July 8, 1982

RE: FRUIT ST. DOWNTOWN HOUSES DRAINAGE PLAN

I have reviewed the referenced drainage report and forward the following comments:

### ORFICE PLATE DETAIL

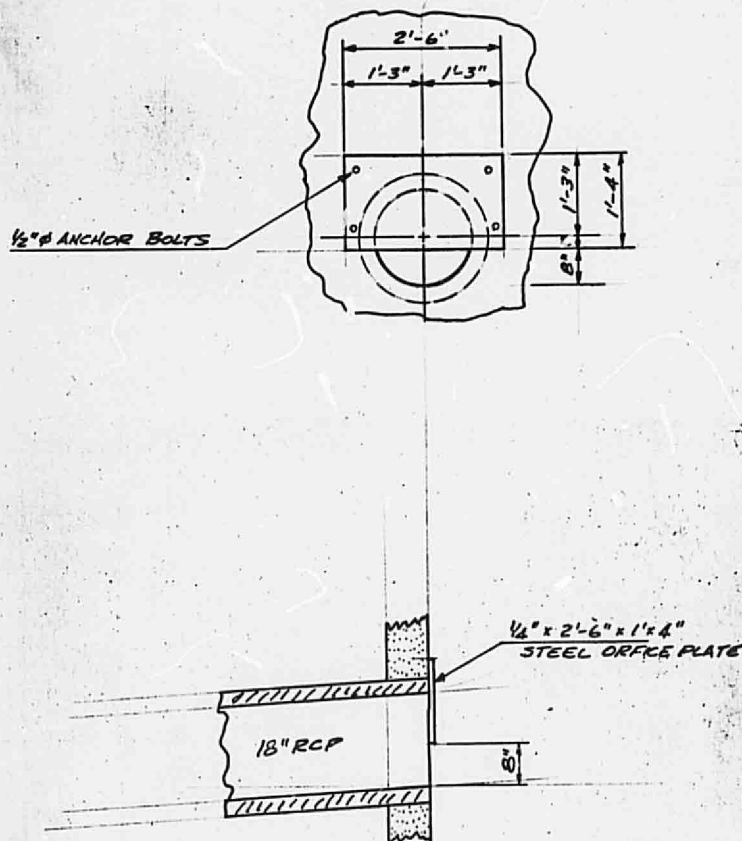
- f. Due to the unpredictable nature of the valley storm-sewer system, the runoff from the site must be discharged at a controlled rate.
- g. Approved copies of Special Order No. 19 must be attached to the City Construction sets before a building permit is issued.

CITY OF ALBUQUERQUE MUNICIPAL DEVELOPMENT DEPARTMENT ENGINEERING DIVISION					
TITLE: FRUIT ST. DOWNTOWN HOUSES GRADING PLAN					
APPROVALS	ENGINEER	DATE	APPROVALS	ENGINEER	DATE
City Engineer			Liquid Waste		
A.C.E.-Design			Traffic		
A.C.E.-Hydrology			Water		
DRAWING NO.	MAP NO. J-14		SHEET OF

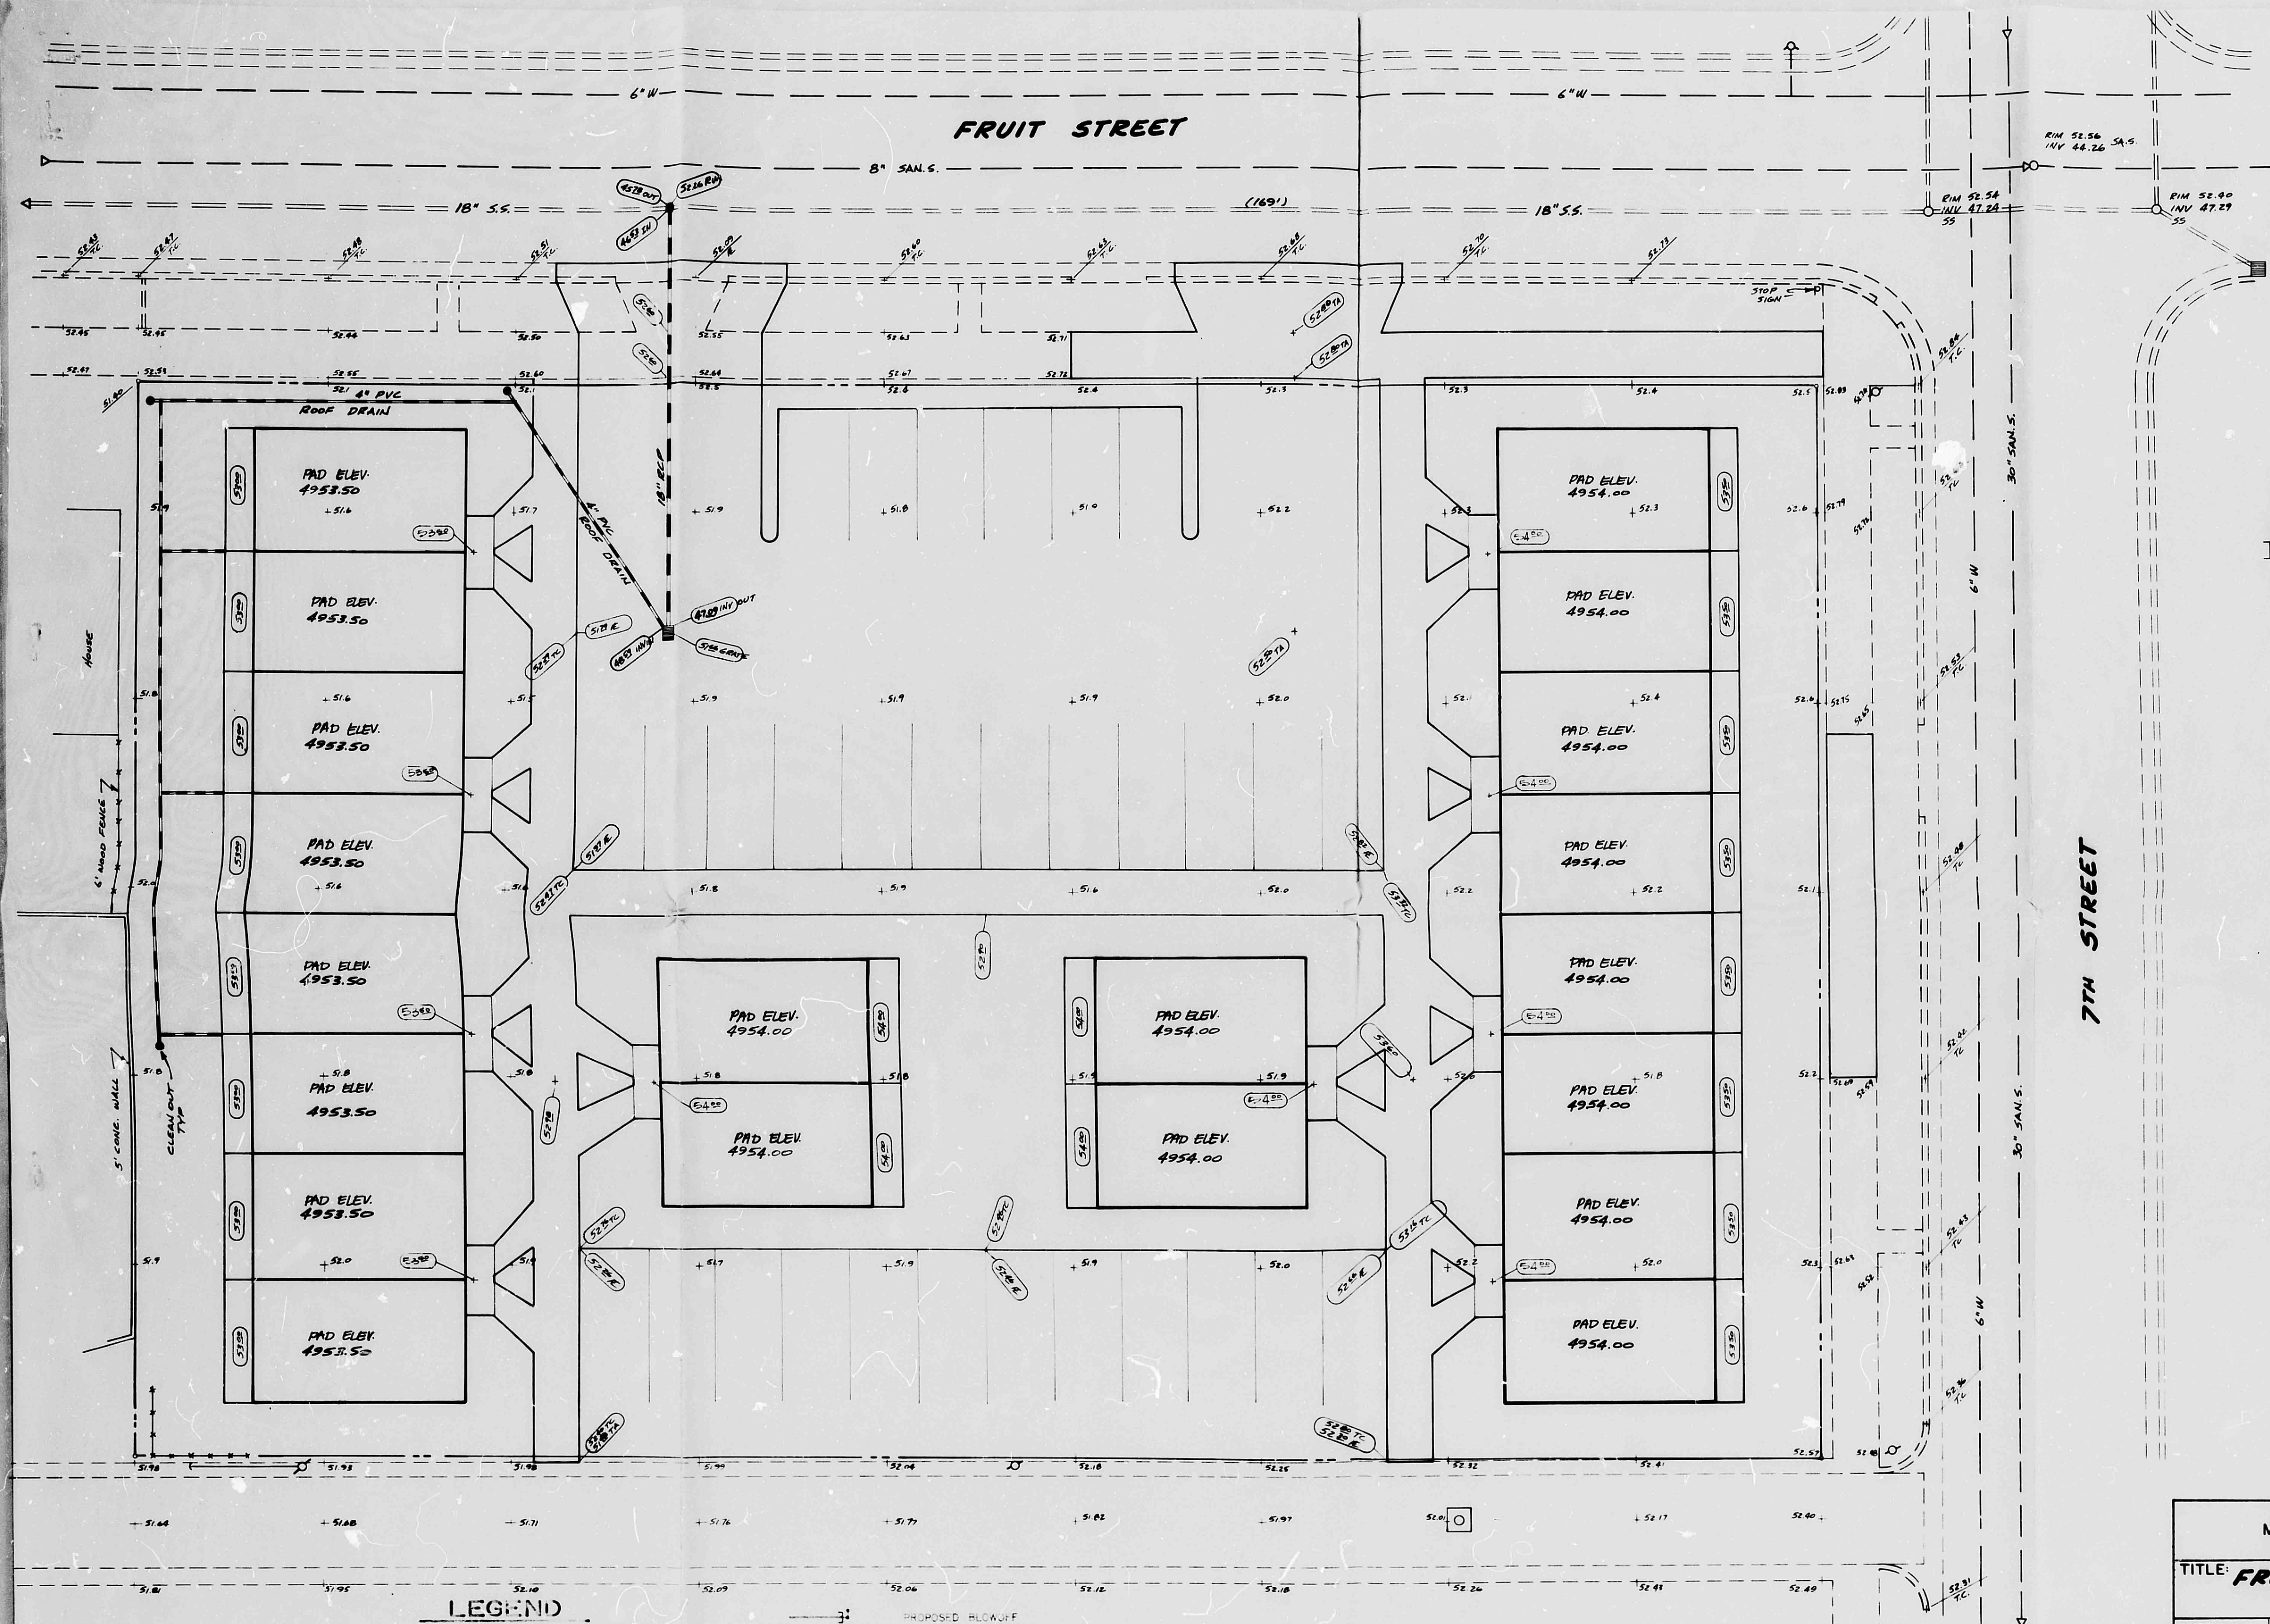
- a. Please clarify how the 4" PVC roof drain will operate and include backup calculations. Why aren't all the units along the west property line connected to the system?

- b. What provisions have been made for maintenance and cleanout of the system? Will clogging of the pipe be an ongoing problem?
- c. Could the runoff generated by Area C be routed through a swale and into the parking area?

- d. How is runoff directed from the units into the parking area and alley? Details for routing the runoff internal to the site should be provided.
- e. What is the maximum runoff volume that can be stored in the parking area if the storm drain system plugs?
